**Re: Chick-fil-A**  
**4001 Coors Blvd. NW**  
**Traffic Circulation Layout**  
Engineer's Stamp 06-20-22 (G11-D069C)

Based upon the information provided in your submittal received 06-23-22, the above referenced plan cannot be approved for Building Permit until the following comments are addressed:

SHEET TITLE  
TRAFFIC  
CIRCULATION  
LAYOUT

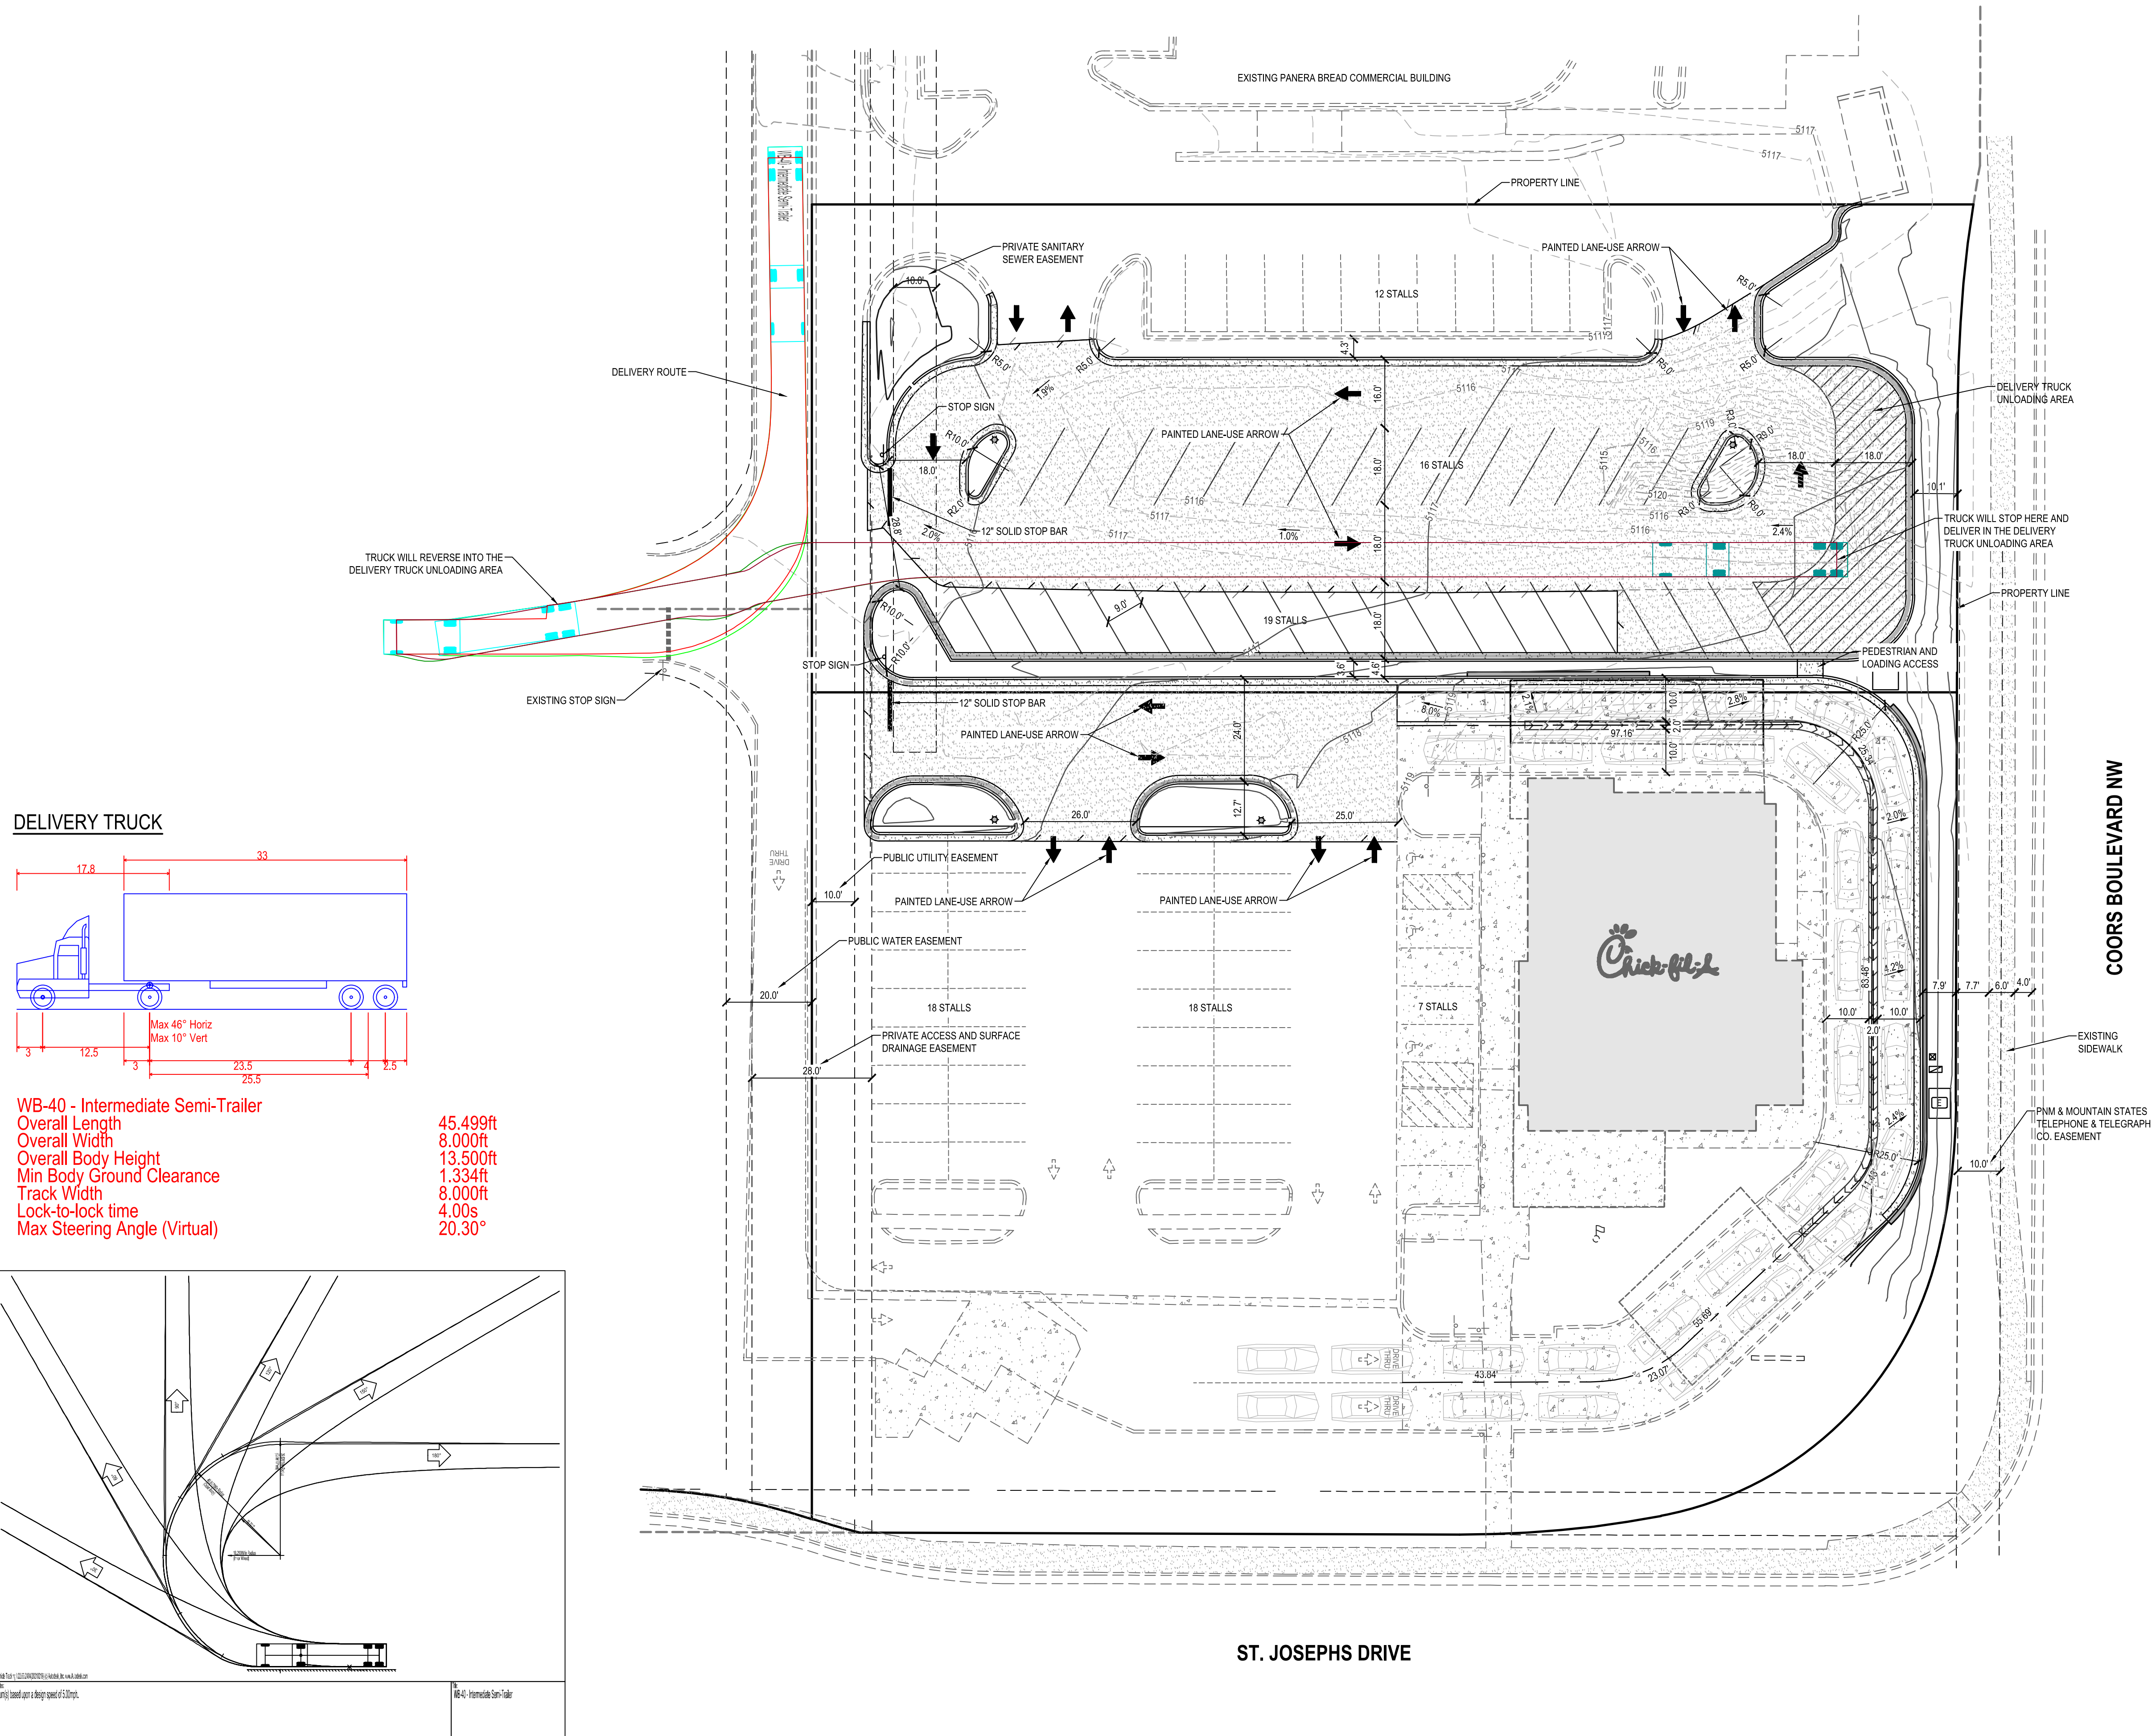
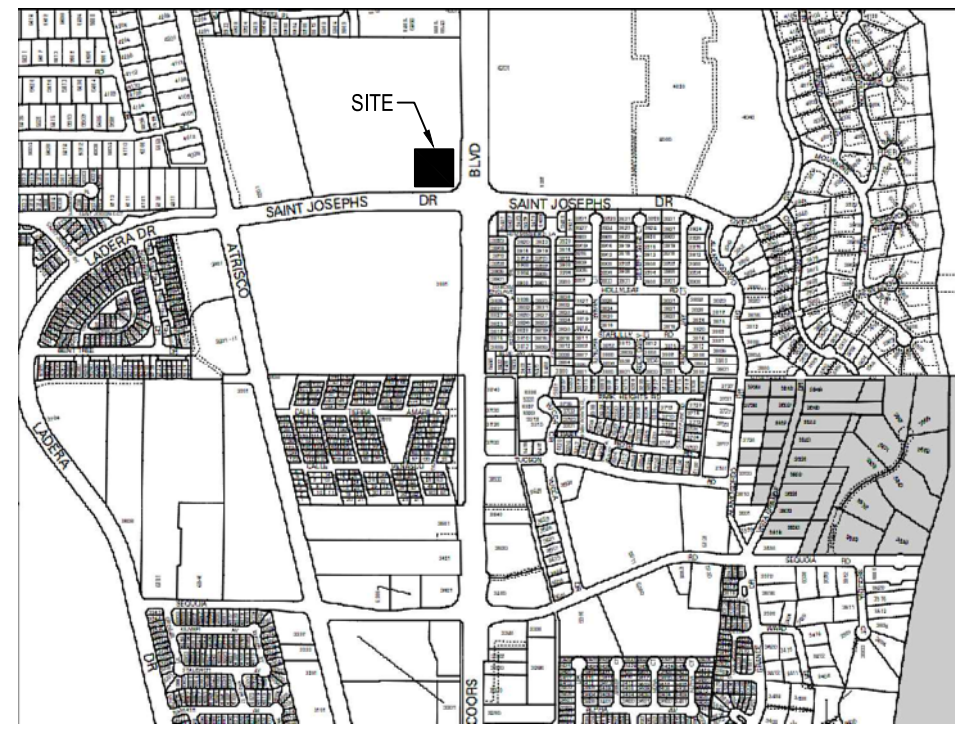
1. Please provide a clear site plan.
2. Provide shared parking agreement.
3. Provide drive aisle width.
4. Provide the angle, length, and the width for the proposed parking spaces.
5. Provide the width for the proposed driveway accesses.
6. It is not apparent what type of pavement surface is being proposed for the angle parking spaces at the north side of the drive-thru. A hard driving surface will be required as part of this proposed project for parking area and drive aisles.
7. The driveway access at the west side of the site, should be used as an Exit Only. Please provide "DO NOT ENTER" sign on this access.
8. All one-way drives shall have "One Way" and "Do Not Enter" signage and pavement markings. Please show detail and location of posted signs and striping.
9. Please provide all proposed signs face details.
10. Please provide a letter of response for all comments given.
